About the application

Application number: 2024/92026	
What is the application for?:	Erection of detached dwelling
Address of the site or building:	adj, 44, Dewsbury Gate Road, Dewsbury, WF13 4DD
Postcode:	WF13 4DD

DRG:
PROPOSED SITE PLAN

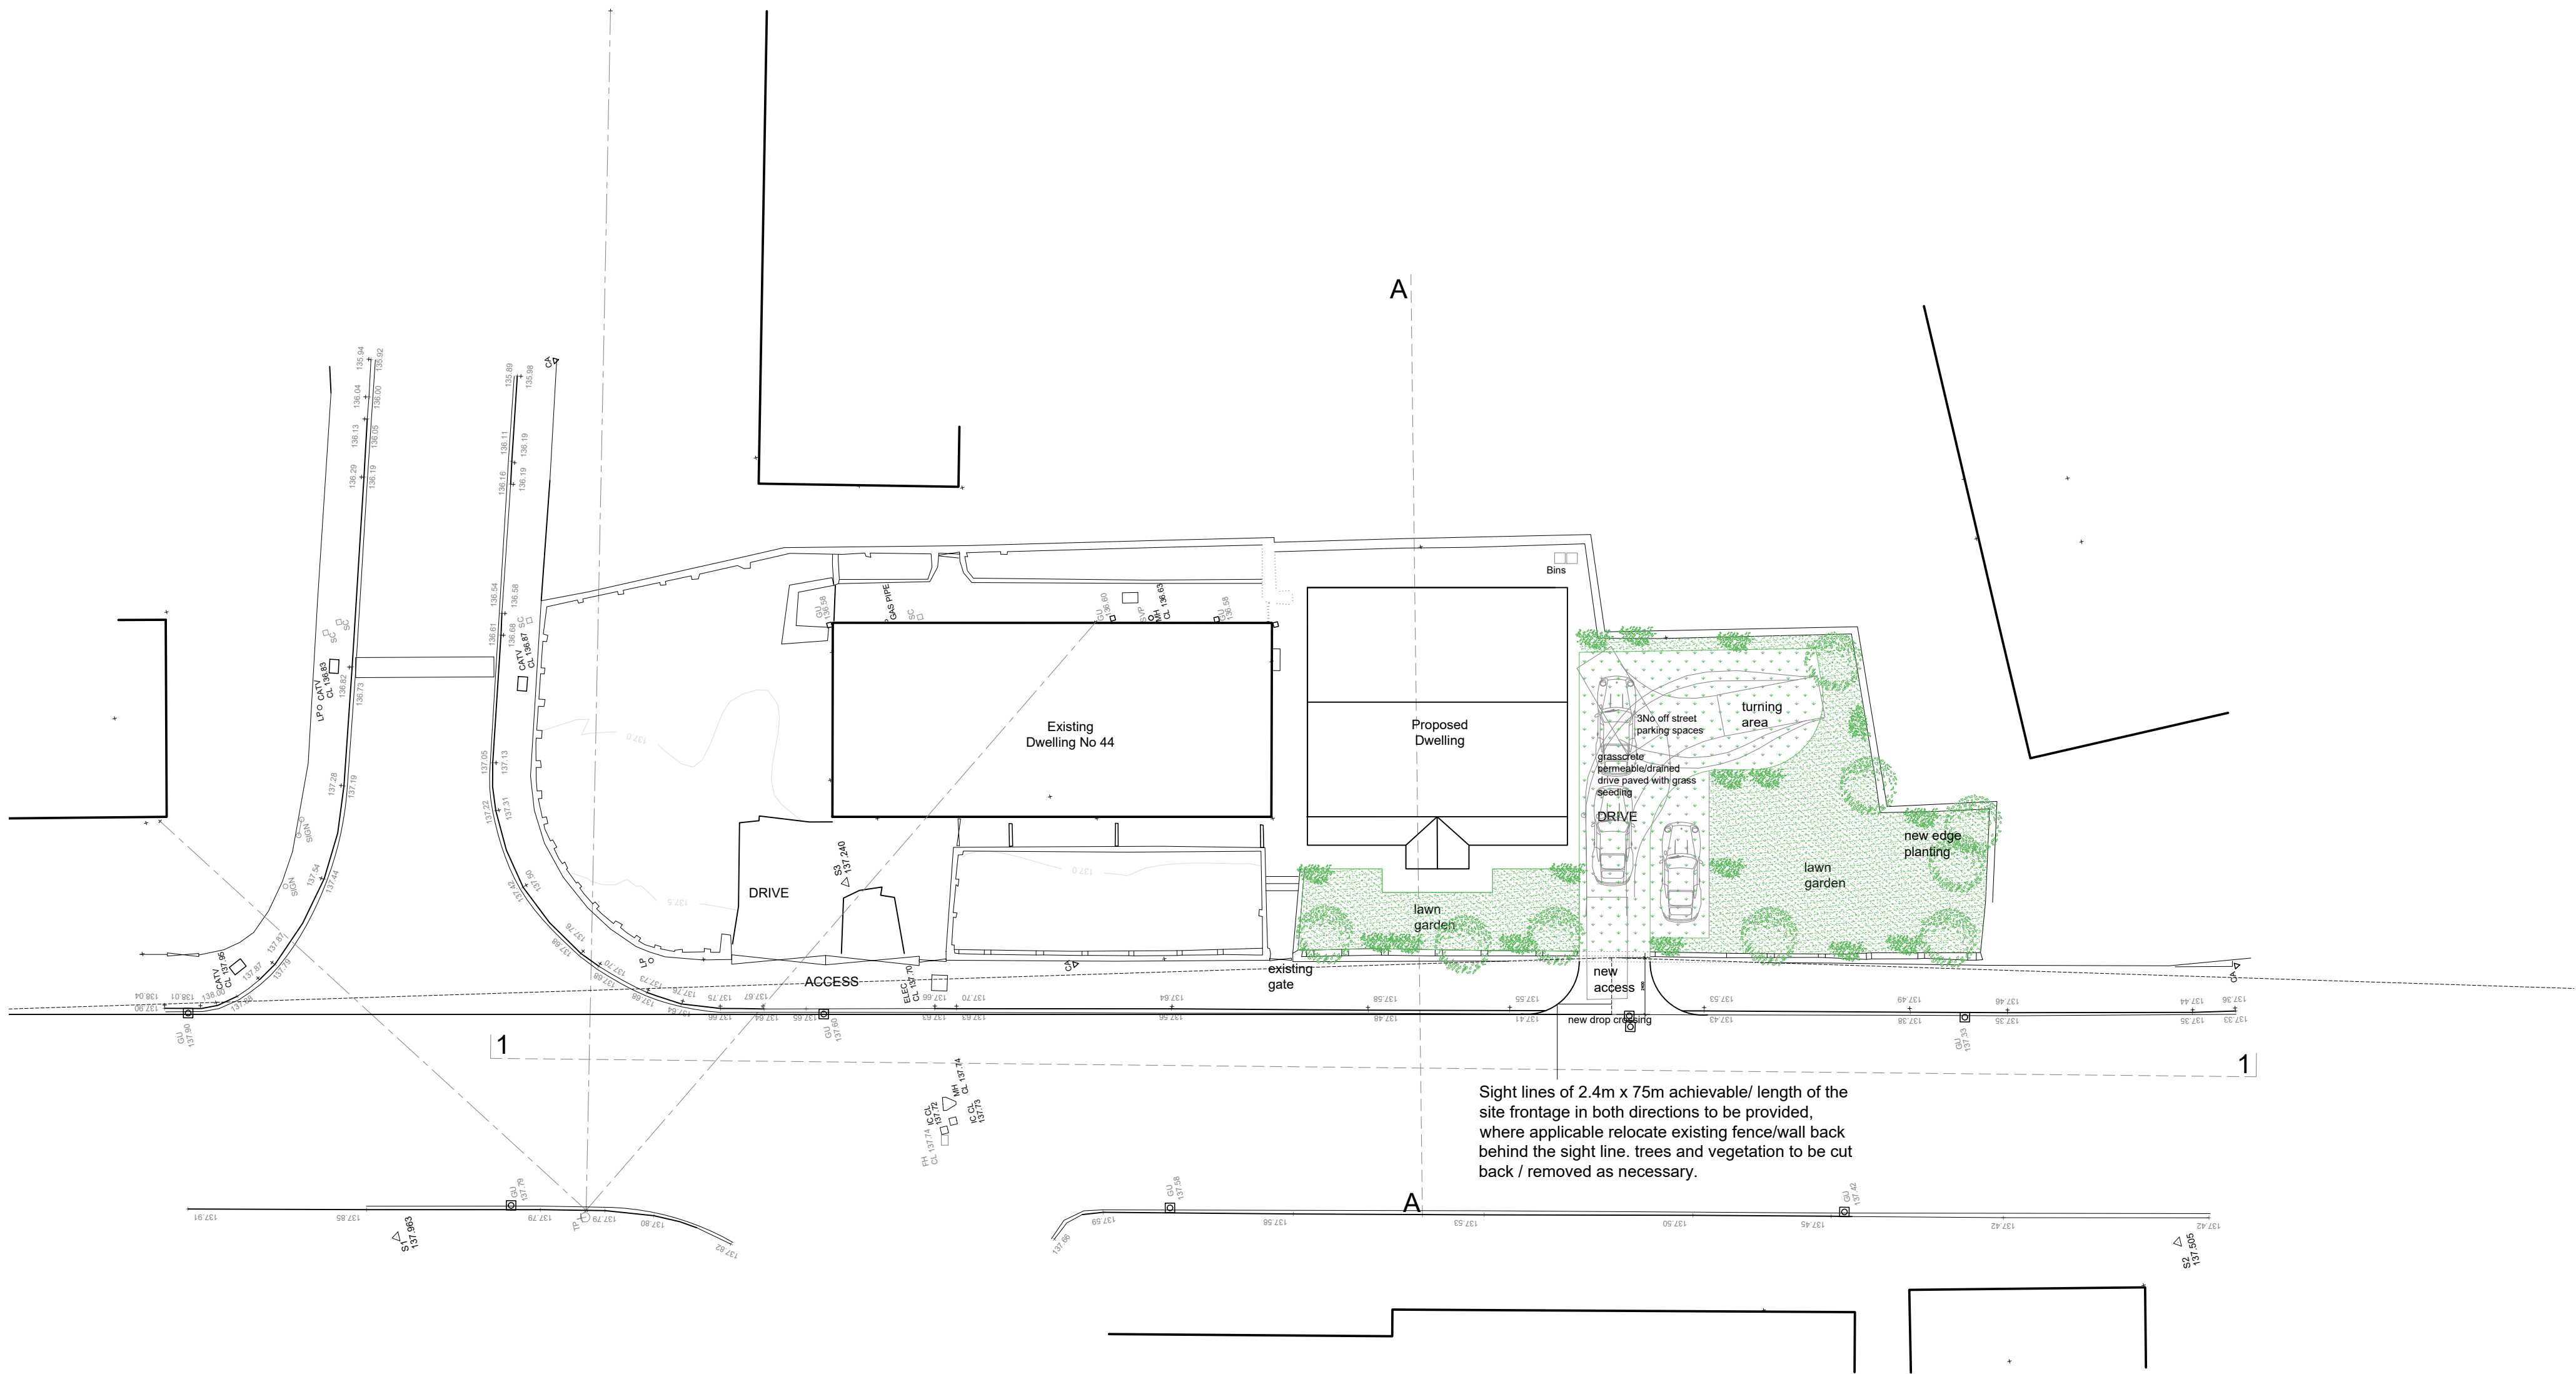
Type of comment: An objection	
Do you wish your comments to be published on the website anonymously?	Yes
This idea will impact on the houses along the side of the proposed property, 14-20 dewsbury gate road, the area of building is higher than our houses so the house will be almost 3 storeys above ours, they have cut down at least 15 trees to free up this area which has already disrupted our privacy, this property will disrupt the privacy of our whole street as it will overlook and tower over all of the street, it's forcing people to already look to move houses, this development will look out of place where it's planned as the houses surrounding are very old, my neighbours have passed a comment that this sort of planning has been rejected in the past for these reasons but they have already proceeded with cutting the trees down before submitting planning permission this time, they burn rubbish all the time so we are worried that this will now be closer to our property as well I would like to reiterate that they have cut down loads of trees for this
